**Our Ref: M/110/11/
Your Ref:**

Please ask for:
Mrs S Honney-Bayes
01903 737500 Ext 37445
30th November 2011

**Application for outline planning permission with all matters reserved for proposed replacement of existing chalet bungalow with new 4 bed chalet bungalow
90 Ancton Way Middleton-on-Sea**

LOCATION PLAN

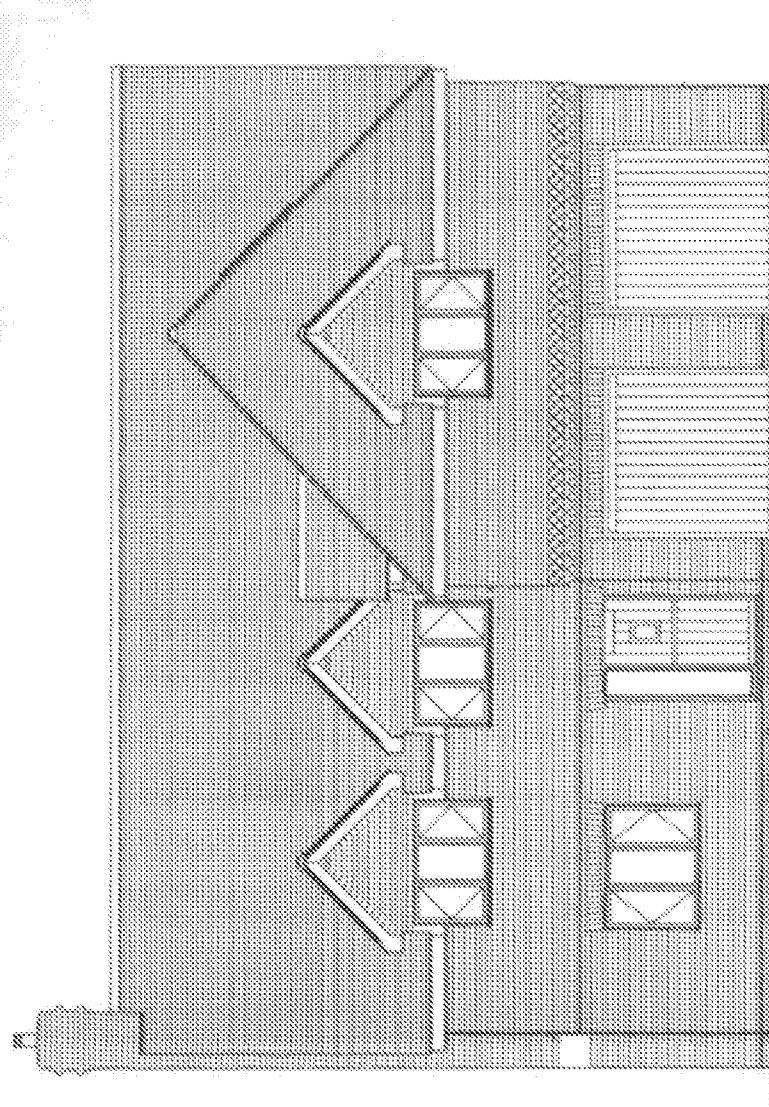
I require 1 electronic or 3 paper copies of a revised location plan to show a red edge around the whole of the application site (not only the footprint of the new dwelling). ✓

SITE PLAN

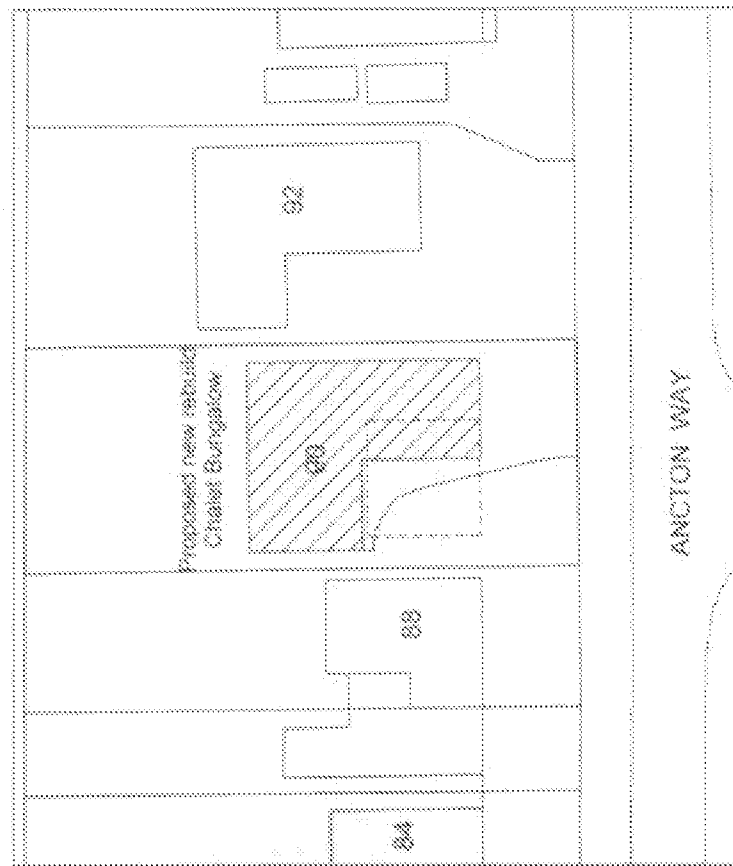
I require 1 electronic or 3 paper copies of a revised block/site plan to show a red edge around the whole of the application site (not only the footprint of the new dwelling). ✓

Please provide details of indicative access points - an area or areas in which the access point or points will be situated. ✓
